Bent Grass East Commercial Filing No. 3

Updated Traffic Impact Analysis

AUGUST 20, 2021

LSC #204660
PCD File No. SP2010

**TYPICAL PRIVATE ROAD CROSS SECTION**  
 SCALE: 1" = 10'  
 BENT GRASS MARKET VIEW  
 (PRIVATE ROADWAY)

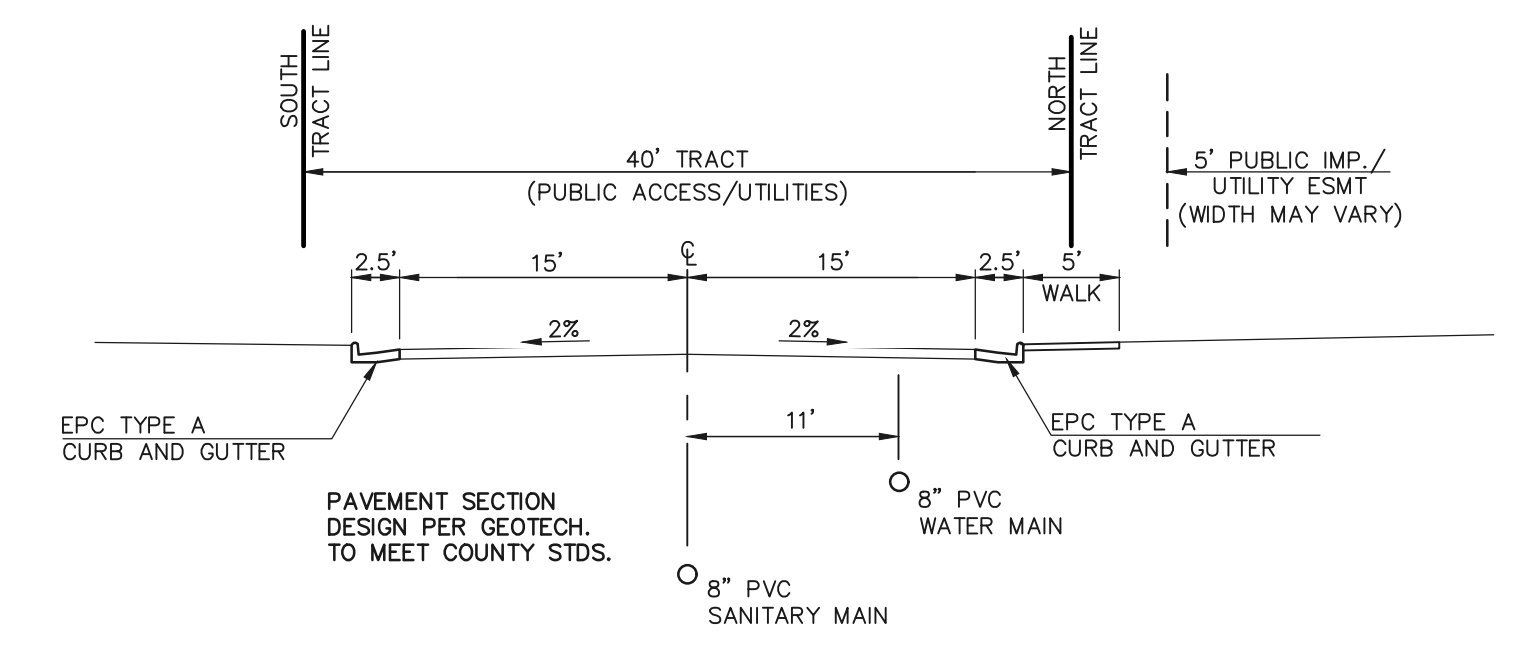
The Preliminary plan shows a 30' to max. 32' cross section. Please coordinate with each other so that the report and plan are consistent. If this is 34' flow line to flow line then please state that. If you determine that a 34' paved cross section is required please have them change the plans accordingly.

LSC Response: The street is proposed to be 34' flow line to flow line and 30' paved. Clarification has been added to the report.
